DECISION DELEGATED TO HEAD OF PLANNING

Application No: H09-0913-22 **Applicant:** Mr D Cook
Proposal: Residential Development - Erection of 5 Houses
Location: Off Farrow Avenue Holbeach Spalding
Terminal Date: 13th October 2023

CASE OFFICER ASSESSMENT

INDICATIVE
SITE LAYOUT

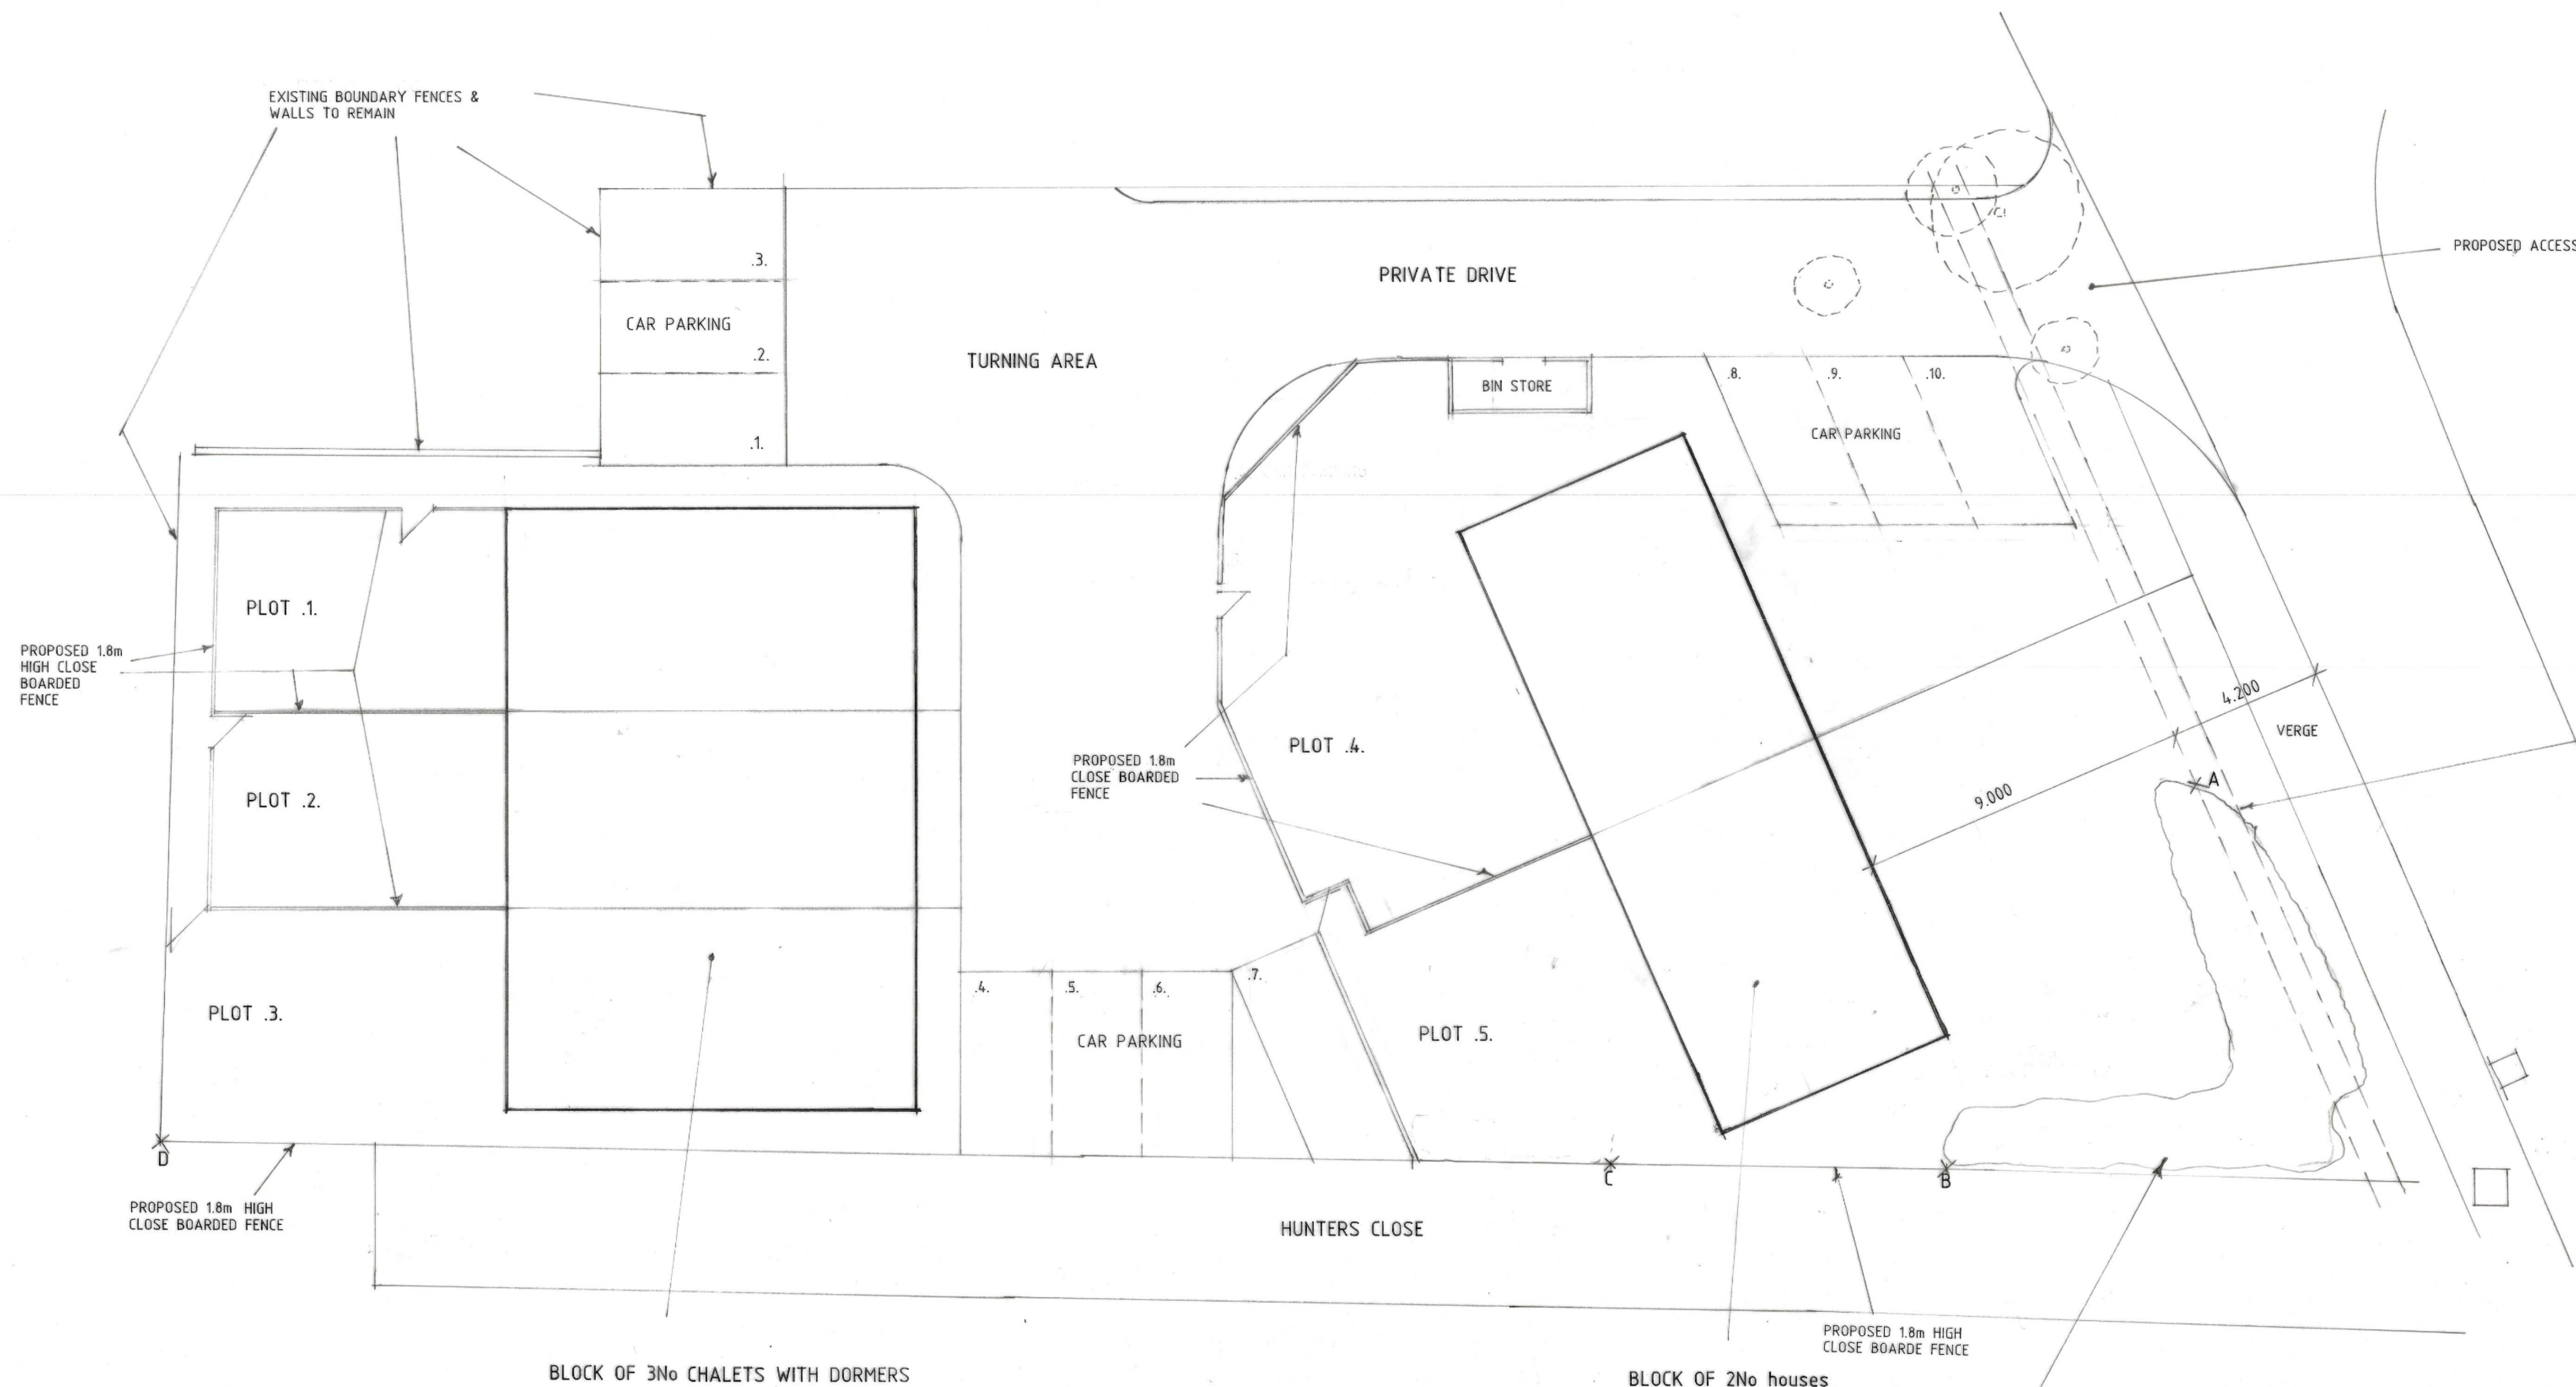
An indicative layout has been submitted showing each house having a small amenity area, and are grouped in two rows of dwellings with a pair of semi-detached properties at the front of the plot and three terraced dwellings at the rear.

The scheme was originally for 6 houses but amendments were necessary due to comments received from the IDB, due to the presence of an IDB drain at the front of the site along Farrow Avenue, acting as a constraint on the site because no development can occur within 9m of the drain according to the IDB's regulations.

The scheme has also been amended to allow for sufficient amenity space for each dwelling, to demonstrate that 5 dwellings with sufficient amenity space can physically fit onto the site.

Amendments have also been made to in relation to boundary hedges. The hedge along the corner of Farrow Avenue and Hunters Close is to be retained, the Leylandi hedge fronting Hunter's Close is to be removed. Neither of these hedges are subject to Tree Preservation Orders and the site is not within a Conservation Area.

Byelaw 10 From the drawing 'SD19-026/2' it appears that the applicant intends to erect the proposed dwellings and car parking area within 9 metres of the aforementioned Board maintained watercourse. This proposal is not acceptable under the Board's Planning and Byelaw Strategy due to the proximity of the proposed dwellings to the Board Maintained watercourse, therefore the Board

All considerations associated with layout and design are reserved for the reserved matters stage. However, an indicative layout has been amended which fits 5 dwellings on site which takes into account the constraint on the site associated with the drain along the front of the plot. The arrangement demonstrates that the site can accommodate 5 dwellings. Detailed design needs to ensure that no front boundary treatment is proposed, and that the front of the properties need to incorporate permeable material at the front such as a landscaped garden. No large trees or further hedges can be planted, but the existing hedge can be retained.

It is noted that requests have been made that parking should be at the rear, with housing at the front. This is not possible due to the presence of the drain and the need to keep 9m in front of the drain clear. Some parking will be allowed in this zone if using gravel utilising grasscrete or similar, to allow for permeable material to be added so as to not worsen flooding. A small amount of tarmac is to be allowed by the IDB under their regulations to ensure the access in principle can be accommodated, however this is also reserved for future consideration. Highway requirements can be added as a note on the permission to guide the detailed design.

This has received consideration by the applicant, but he wants to remove the Leylandi hedge, as he states it is in a poor condition. Residents strongly dispute this. Since this hedge can be removed without needing consent, whilst it is acknowledged that it offers a degree of privacy for the occupiers of Hunters Close, it is considered that planning permission cannot reasonably be withheld if it is removed. Other design aspects can be employed to ensure that privacy or overlooking does not occur to the occupiers of Hunters Close, by paying close attention to the detailed design of the dwellings at the reserved matters stage, and to not allowing permitted development and also disallowing flank windows by condition, and restricting the overall storey height at the rear.

A 1.8m fence would be installed in place of the Leylandi hedge which is a standard form of boundary treatment. It is considered that this would be acceptable and whilst regrettable that the applicant has chosen not to retain the Leylandi hedge, it is not considered that this could be resisted at the detailed matters stage.

The IDB have said that no structures should be introduced on the front of the premises due to the presence of the IDB drain. The retention of the hedge will provide a form of boundary treatment if retained. No further hedging would be permitted however, and the front gate will need to be removed.

The IDB confirmed that consent was granted for Byelaw 10 on 23/05/2023.

The IDB initially objected to the proposal due to the presence of buildings within 9m of the drain. This has now been resolved and drainage consent has been obtained, demonstrating, via the indicative plans, that 5 dwellings can be put on site without affecting the 9m easement zone next to the drain. The site will need to be kept clear of development in this area. Now that drainage consent has been obtained that resolves the IDB objection.

The applicant has indicated that the front hedge is healthy and will be retained as part of the landscaping. This can be controlled via a suitably worded landscaping condition.
